Addendum No. 1

RE: Contract # C204471
WBS # 45446.3.1
FEDERAL-AID NO. NHS-0421(072)
Wilkes County (U-5312)
US-421 FROM EAST OF NC-16 TO US-421 BUS.

The following revisions have been made to the Utility Construction Plans.

PROJECT REFERENCE NO.	UC-21
U-5312	
DESIGNED BY: B. CLAWSON	
DRAWN BY: R. MOSS	
CHECKED BY: B. CLAWSON	
APPROVED BY:	<i>Benjamin D. Clawson</i>
REVISED: 11-2-23	
MUNICIPAL ENGINEERING SERVICES COMPANY, PA.	
P.O. BOX 97 GARNER, NC 27529 19191772-5393	UTILITY CONSTRUCTION PLANS ONLY

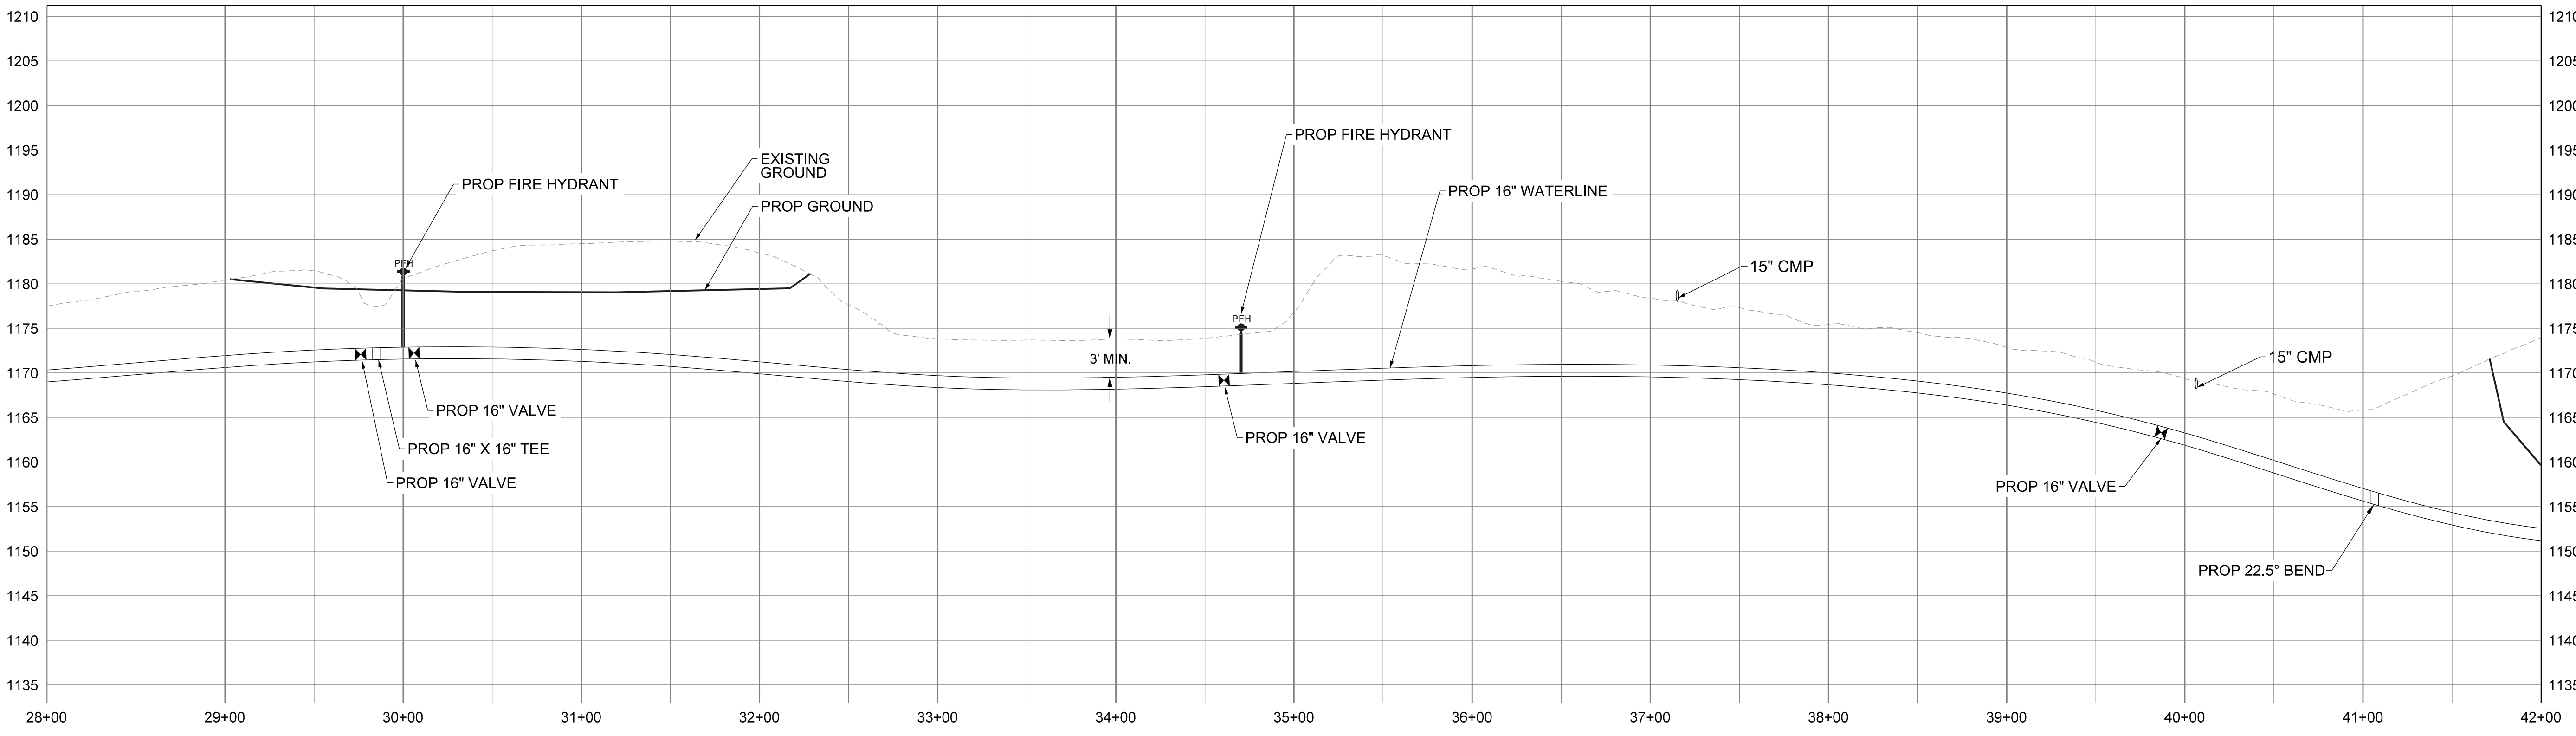
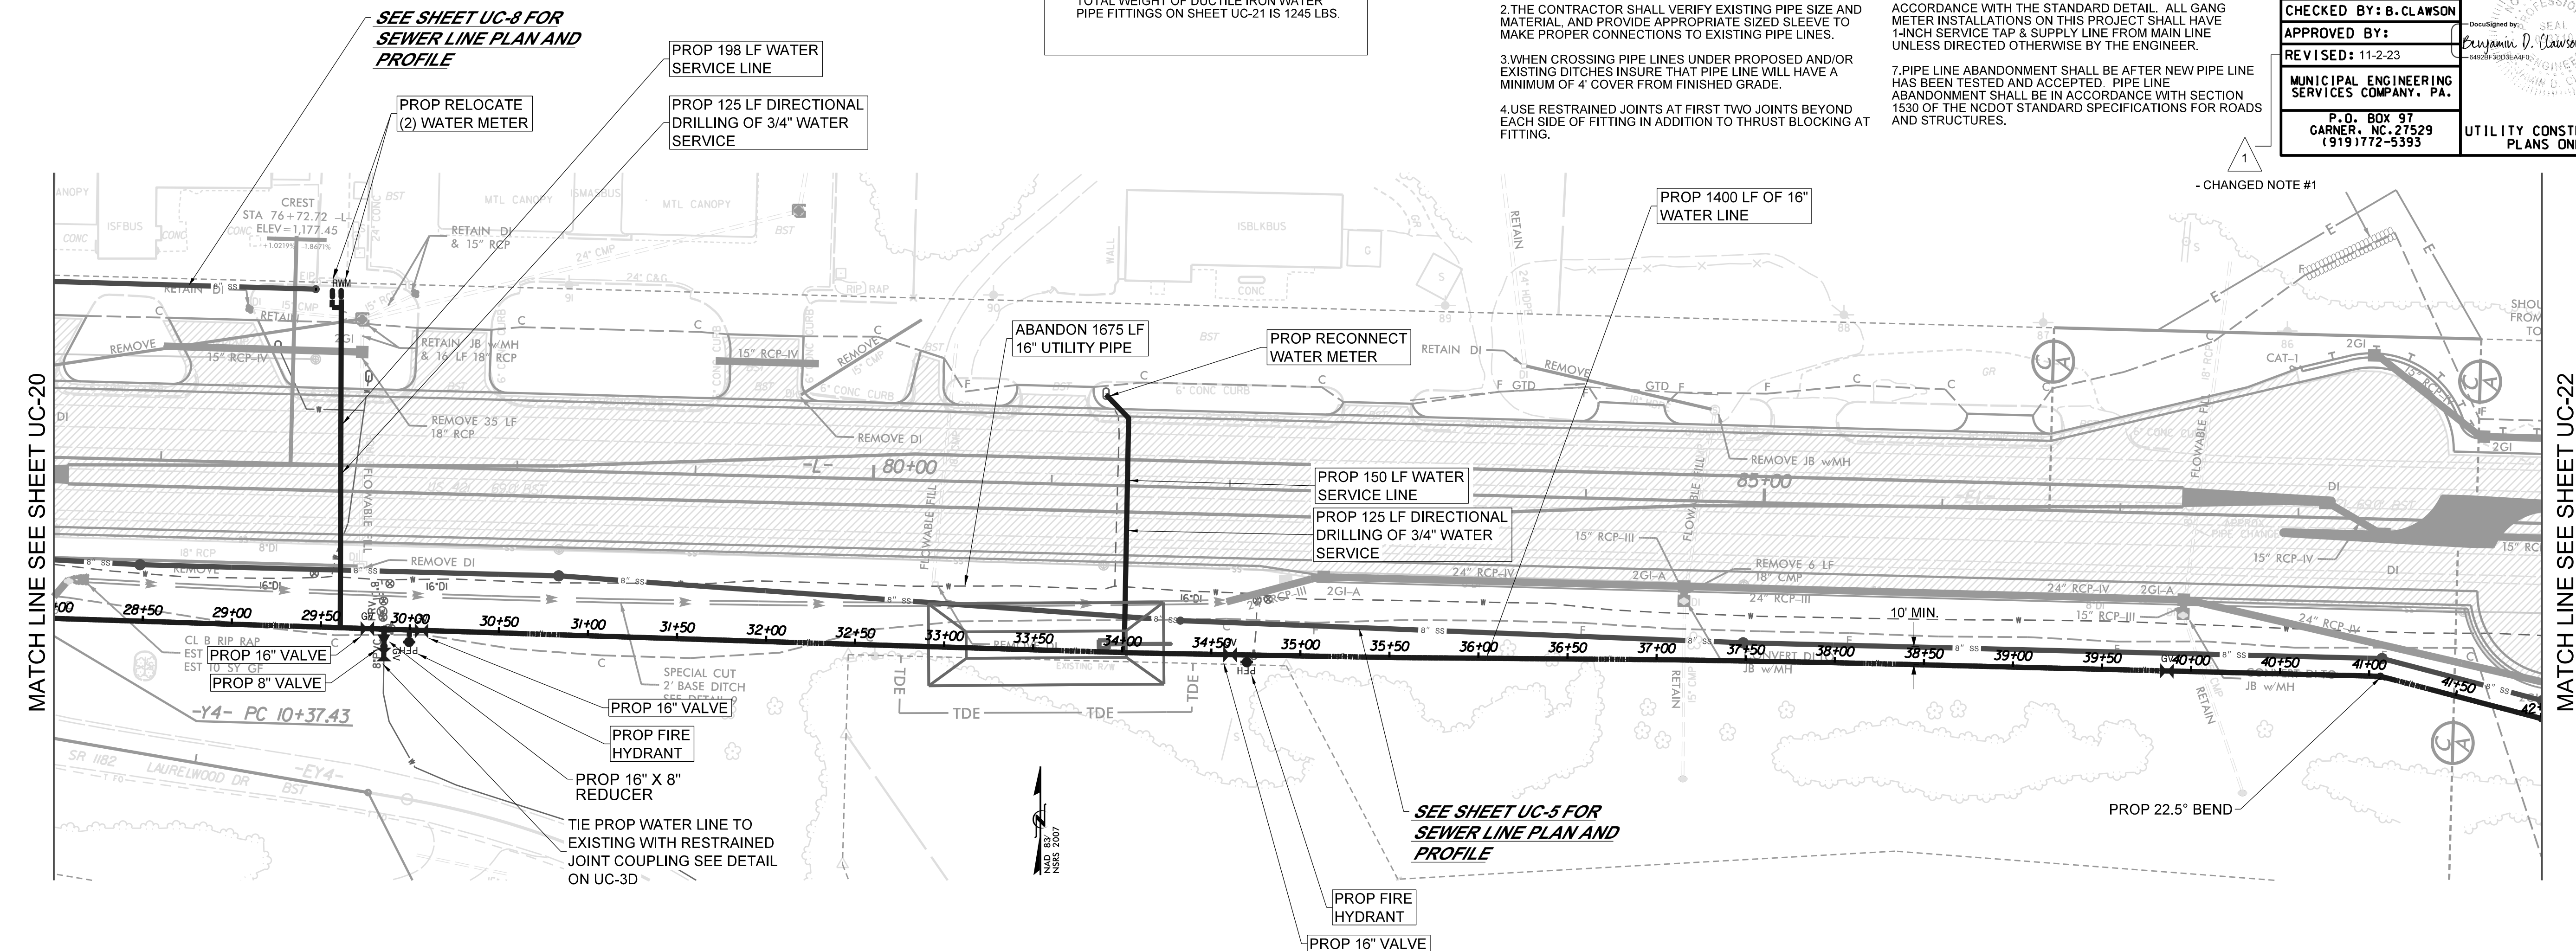
Sheet No.	Revision
UC-21	Revised Note #1 to state "Waterline material shall be DIP-Class 350 (All Open Trench Installations), HDPE-DR7 (Directional Bore Installations), Copper (Service Installations)". Labels added for Proposed 16" Valve and Proposed Fire Hydrant.
UC-22	Revised Note #1 to state "Waterline material shall be DIP-Class 350 (All Open Trench Installations), HDPE-DR7 (Directional Bore Installations), Copper (Service Installations)".
UC-23	Revised Note #1 to state "Waterline material shall be DIP-Class 350 (All Open Trench Installations), HDPE-DR7 (Directional Bore Installations), Copper (Service Installations)".
UC-24 thru UC-25	North arrow added. Additional detail for benched exaction trenching provided in profile. Revised Note #1 to state "Waterline material shall be DIP-Class 350 (All Open Trench Installations), HDPE-DR7 (Directional Bore Installations), Copper (Service Installations)".

PROJECT REFERENCE NO.	SHEET NO.
U-5312	UC-27
DESIGNED BY: B. CLAWSON	
DRAWN BY: R. MOSS	
CHECKED BY: B. CLAWSON	
APPROVED BY:	
REVISED: 5/9/23 11/2/23	
MUNICIPAL ENGINEERING SERVICES COMPANY, P.A.	UTILITY CONSTRUCTION PLANS ONLY
P.O. BOX 97 GARNER, NC 27529 19191772-5393

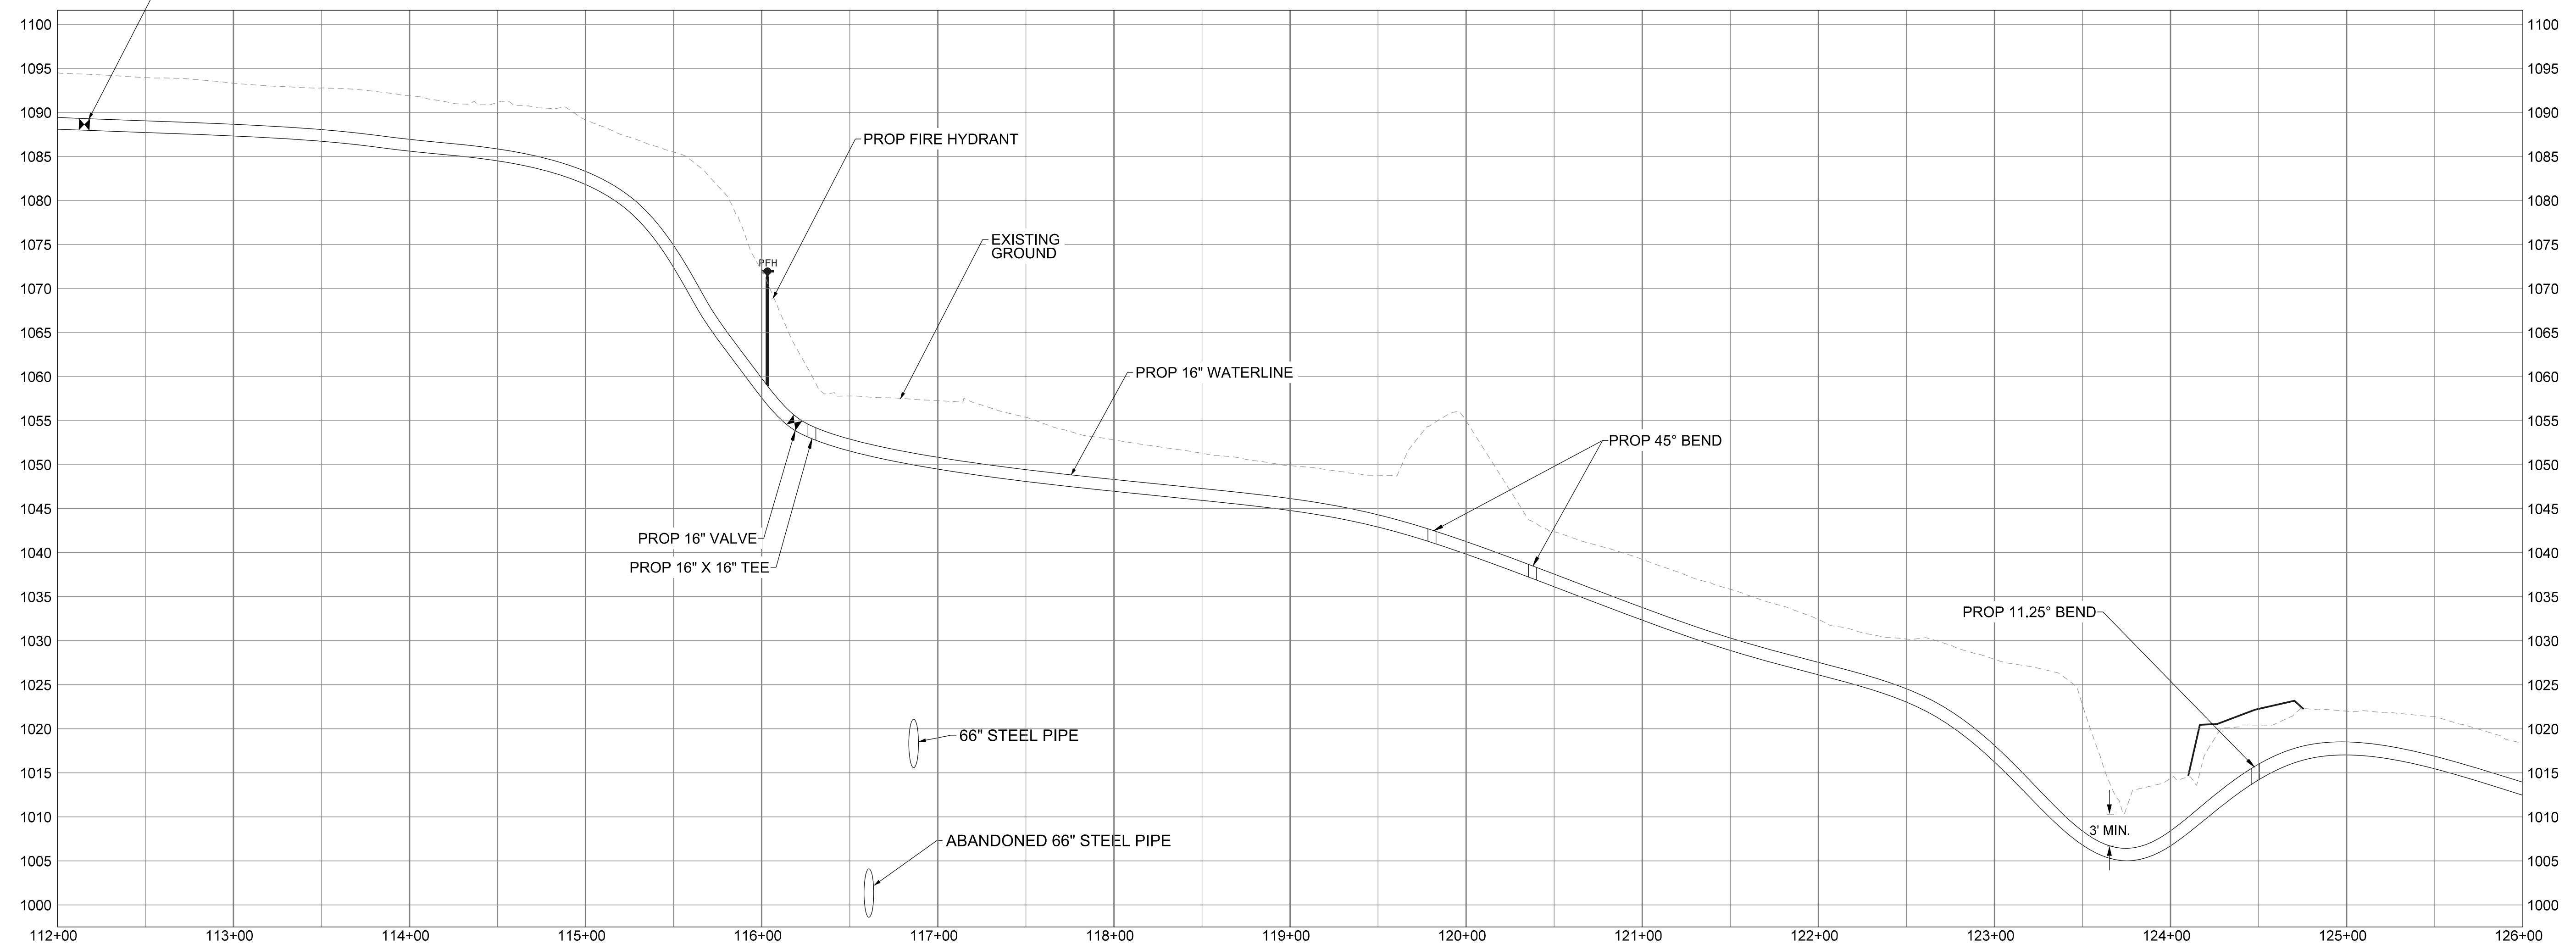
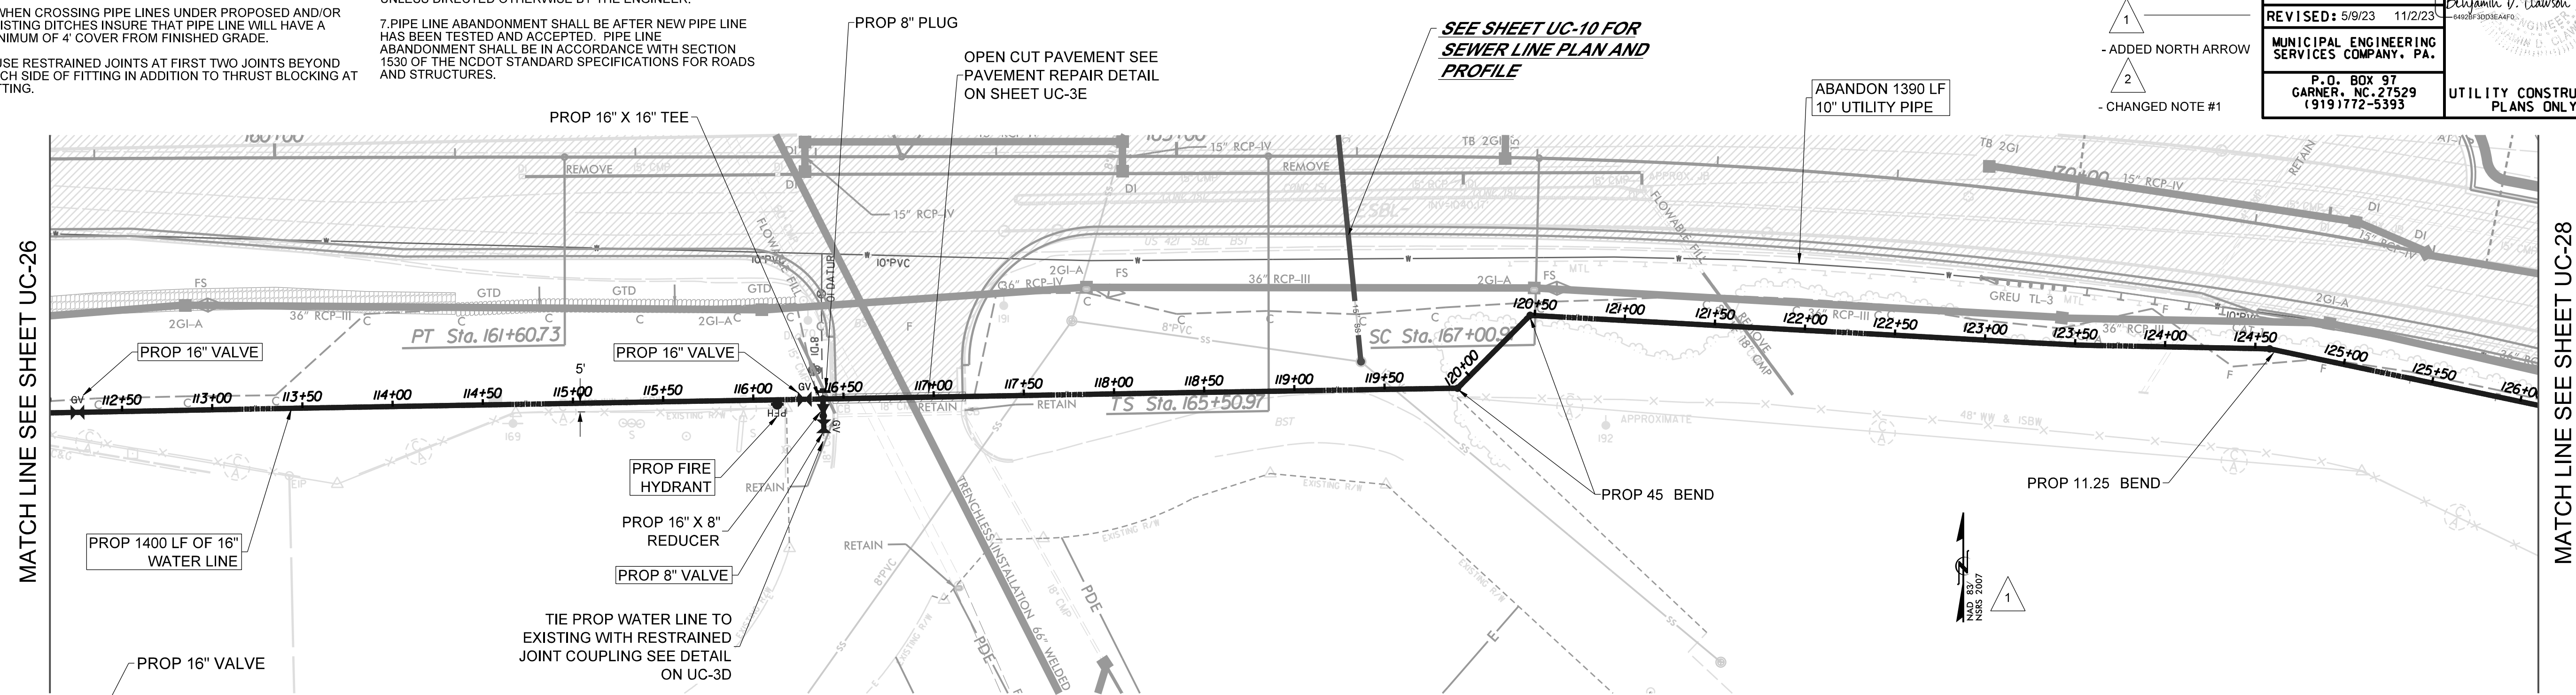
UC-26	Revised Note #1 to state "Waterline material shall be DIP-Class 350 (All Open Trench Installations), HDPE-DR7 (Directional Bore Installations), Copper (Service Installations)".
UC-27	North arrow added. Revised Note #1 to state "Waterline material shall be DIP-Class 350 (All Open Trench Installations), HDPE-DR7 (Directional Bore Installations), Copper (Service Installations)".
UC-28	North arrow added. Labels added in the profile. Revised Note #1 to state "Waterline material shall be DIP-Class 350 (All Open Trench Installations), HDPE-DR7 (Directional Bore Installations), Copper (Service Installations)".
UC-29	Vertical separation adjusted in profile. Revised Note #1 to state "Waterline material shall be DIP-Class 350 (All Open Trench Installations), HDPE-DR7 (Directional Bore Installations), Copper (Service Installations)".
UC-30 thru UC-33	Revised Note #1 to state "Waterline material shall be DIP-Class 350 (All Open Trench Installations), HDPE-DR7 (Directional Bore Installations), Copper (Service Installations)".

SEWER SHEETS LAYOUT (UC-4 - UC-18)

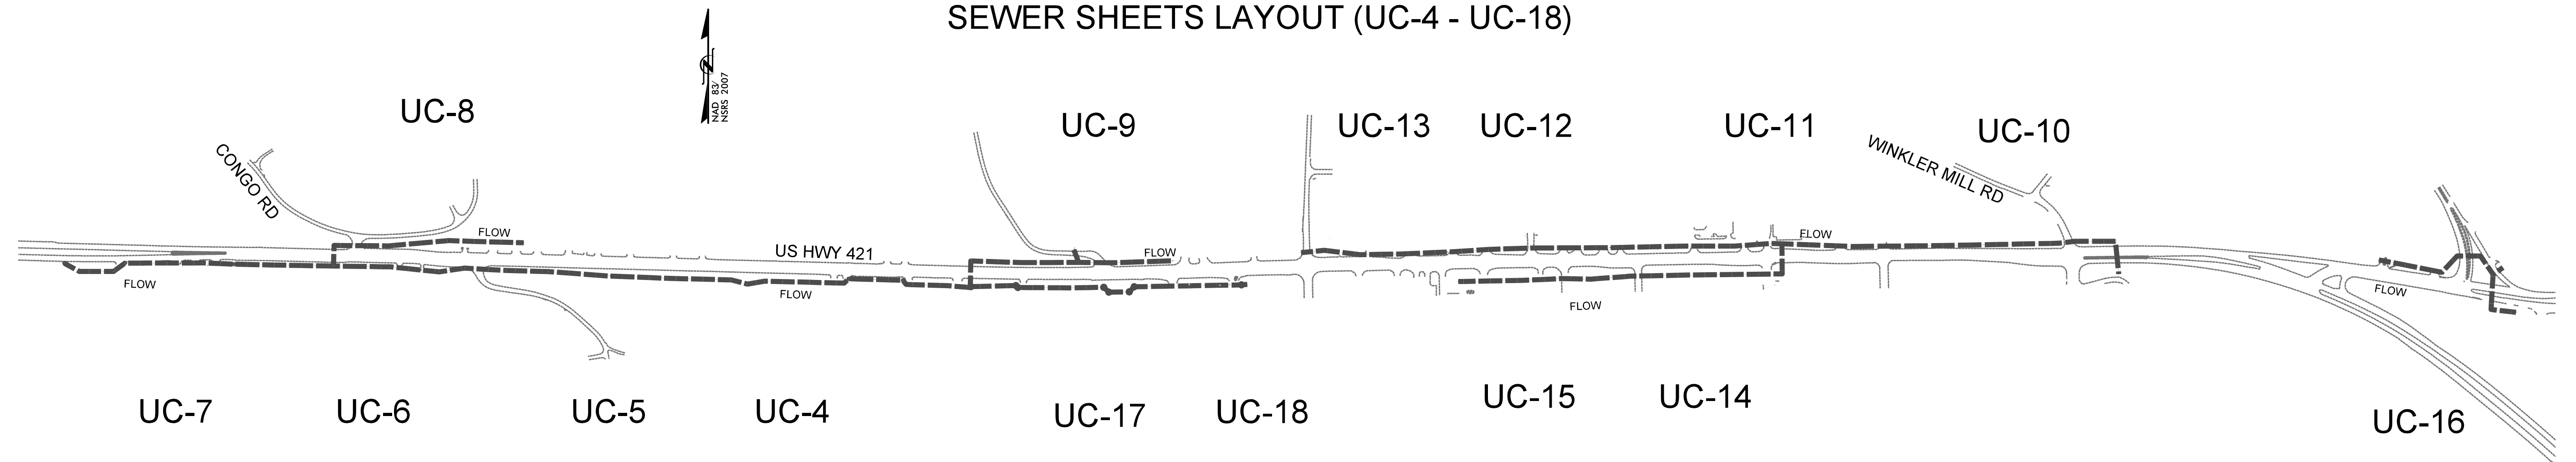
Sheet No.	Revision
UC-2 thru UC-33	All sheets within the Utility Construction Plan set affixed with a Professional Engineer seal and signature have been revised with a digitally signed signature and an execution date of 11/06/23.
UC-4A (New Sheet)	Sewer Sheet Layout (UC-4 thru UC-18).
UC-19A (New Sheet)	Water Sheet Layout (UC-19 thru UC-33).
UC-19	Provided extra clearance between water and sewer lines. Revised Note #1 to state "Waterline material shall be DIP-Class 350 (All Open Trench Installations), HDPE-DR7 (Directional Bore Installations), Copper (Service Installations)".
UC-20	Revised Note #1 to state "Waterline material shall be DIP-Class 350 (All Open Trench Installations), HDPE-DR7 (Directional Bore Installations), Copper (Service Installations)".
